**Consultation Response from KC,
Lead Local Flood Authority**

2024/92842 Land to North and South of, Crossley Lane, Dalton, Huddersfield, HD5 0QP

Discharge of details reserved by conditions 3 (drainage) and 4 (adoptable estate roads) of previous Reserved Matters approval 2020/90805 pursuant to outline permission 2015/90430 for erection of residential development comprising (Use Class C3) and incorporating associated new access (to Crossley Lane and Cold Royd Lane) and associated works (122 dwellings)

Condition 3 – Drainage Details

**DRAWING TITLE:** CROSSLEY LANE, HUDDERSFIELD  
1.8m Dp. MODULAR WATER  
RETAINING TANK  
PROPOSAL DRAWING

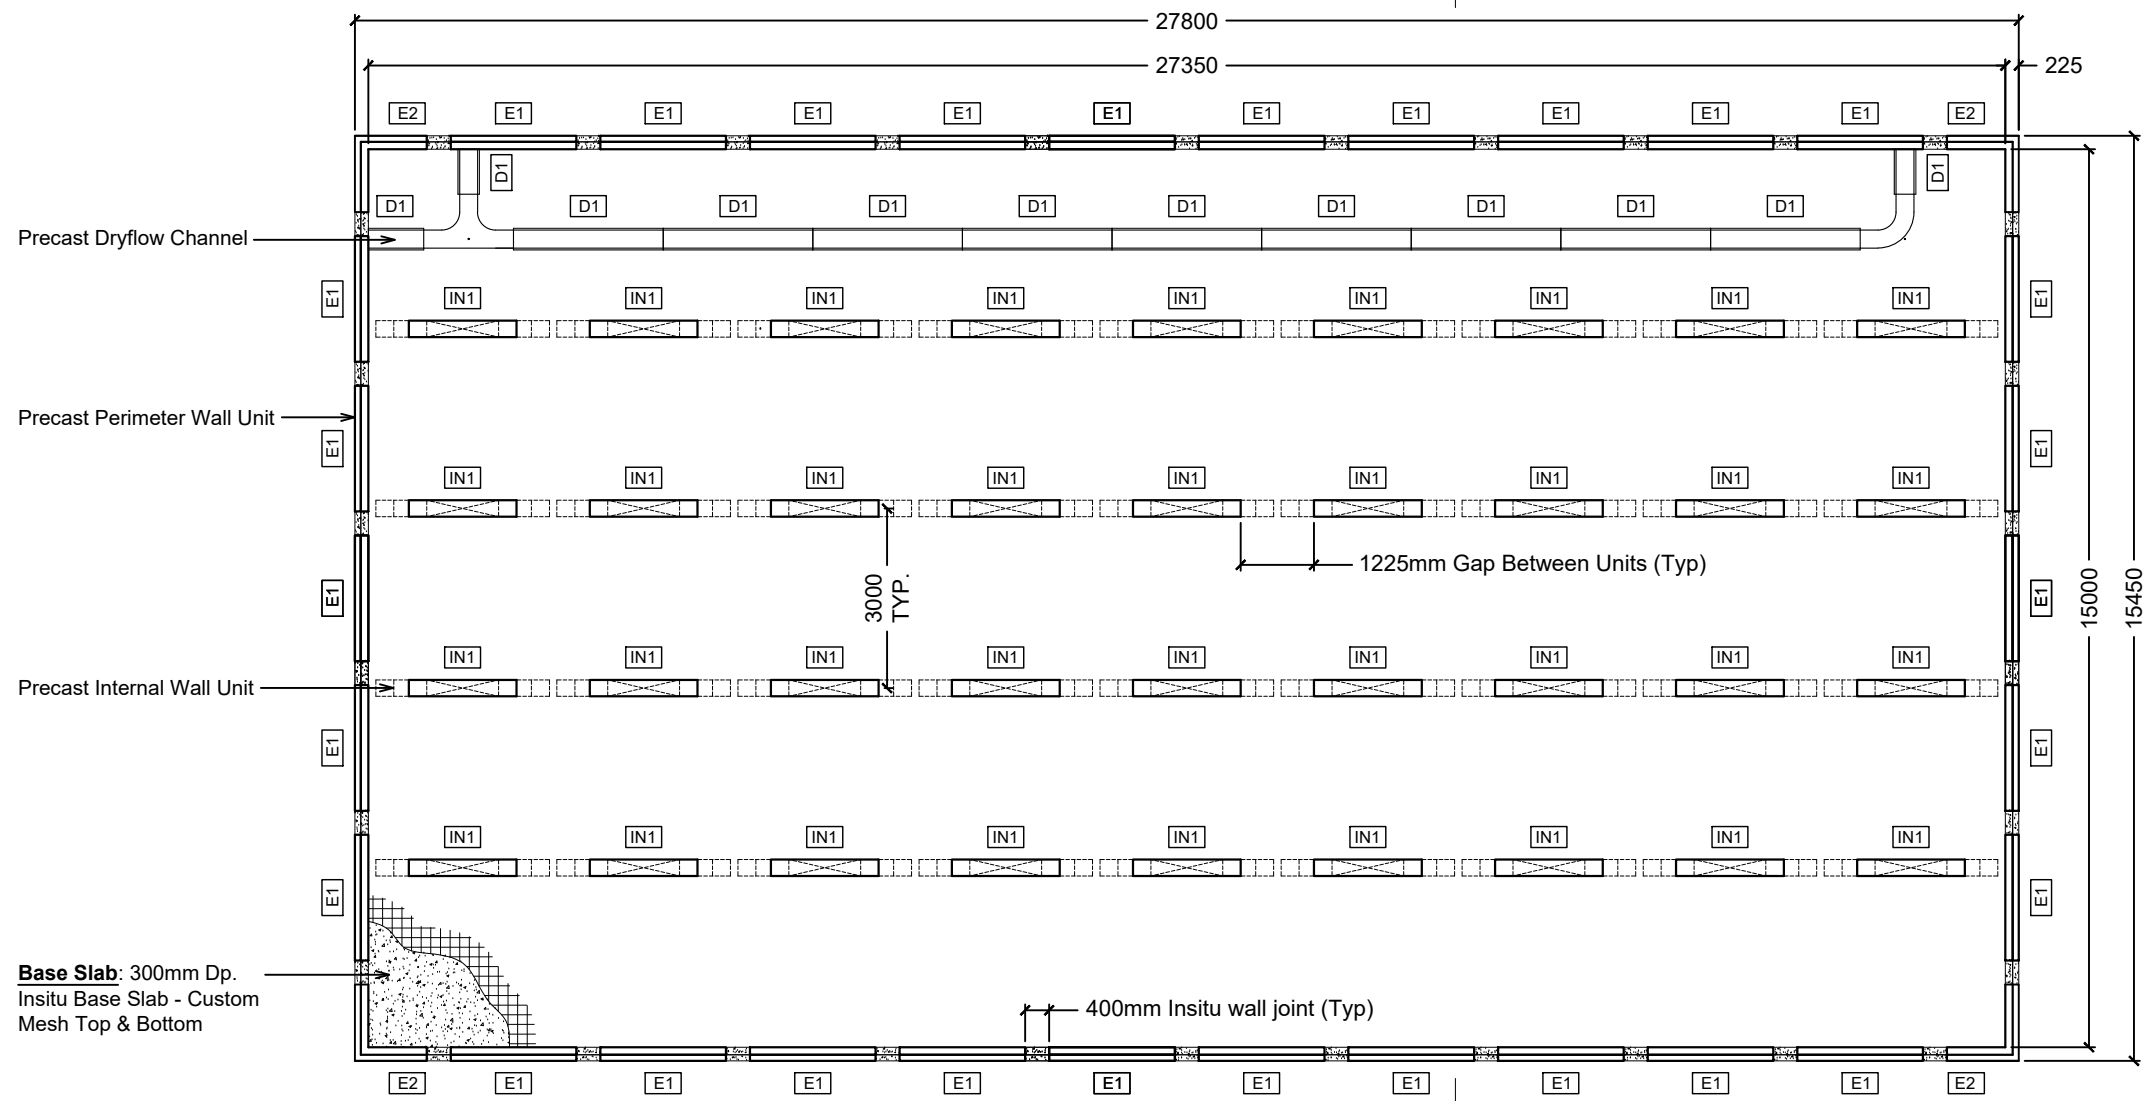
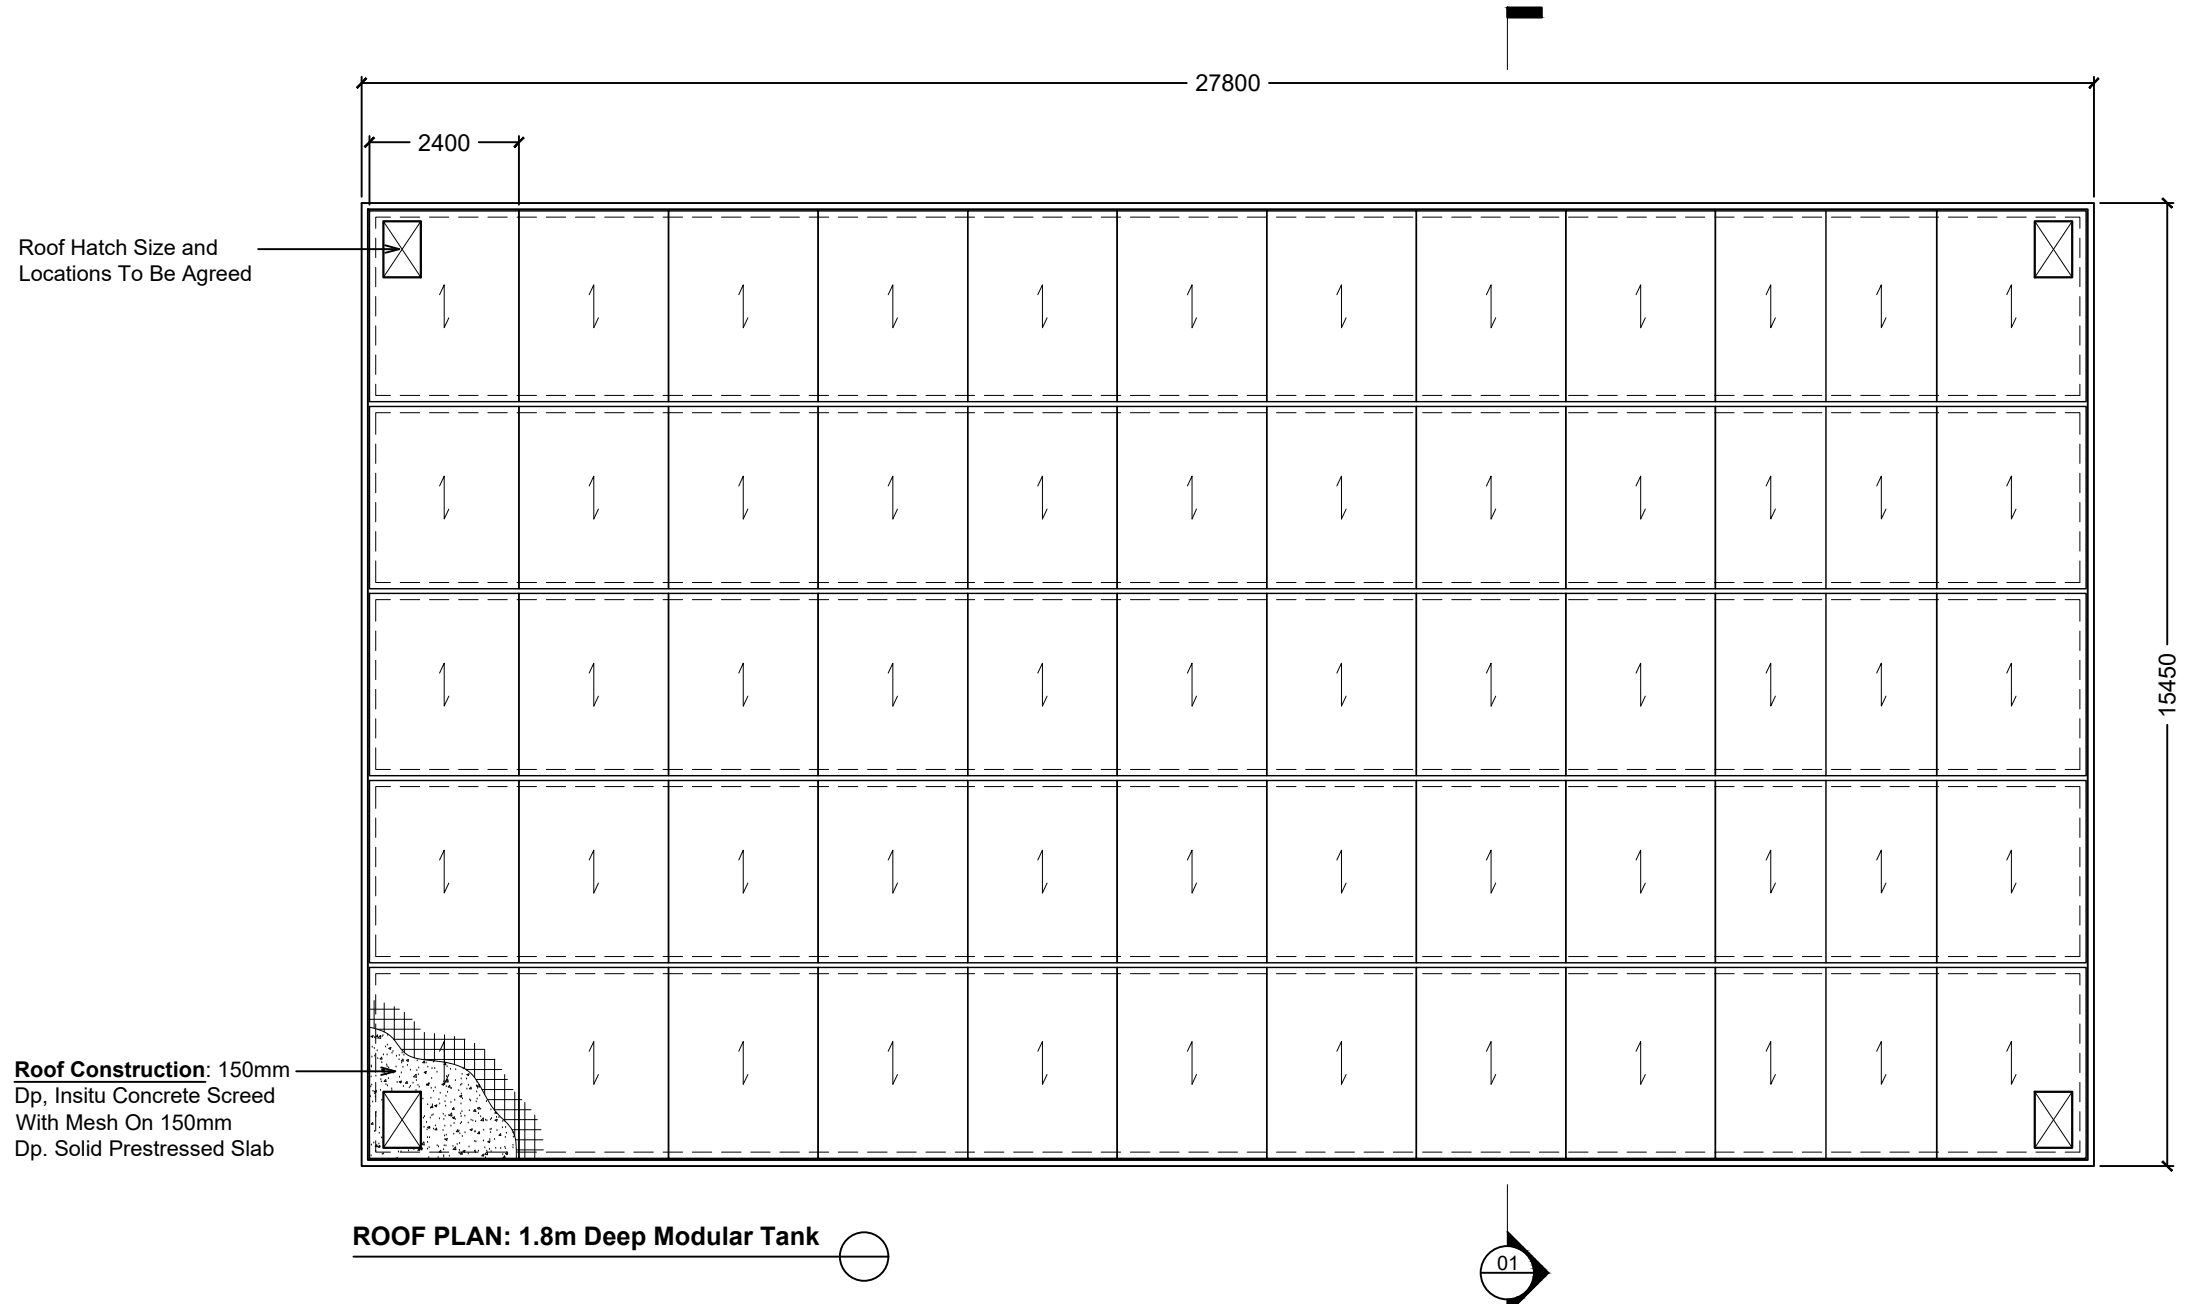
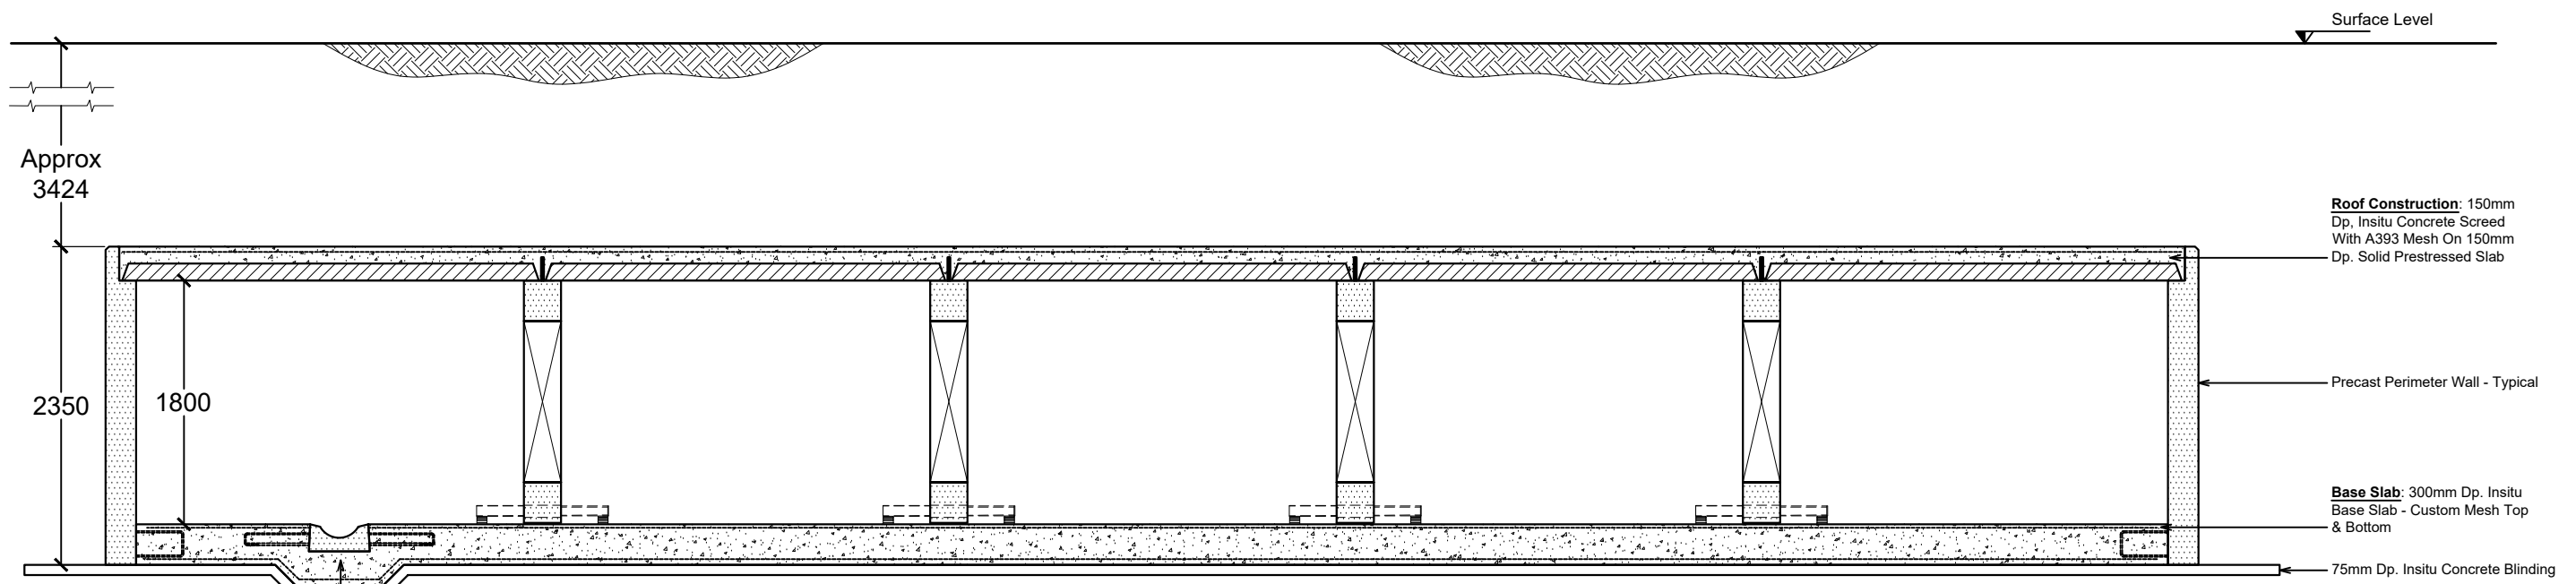
A plan and cross section of the attenuation tank is required to accompany details already provided.

This condition should NOT be discharged at this moment in time.
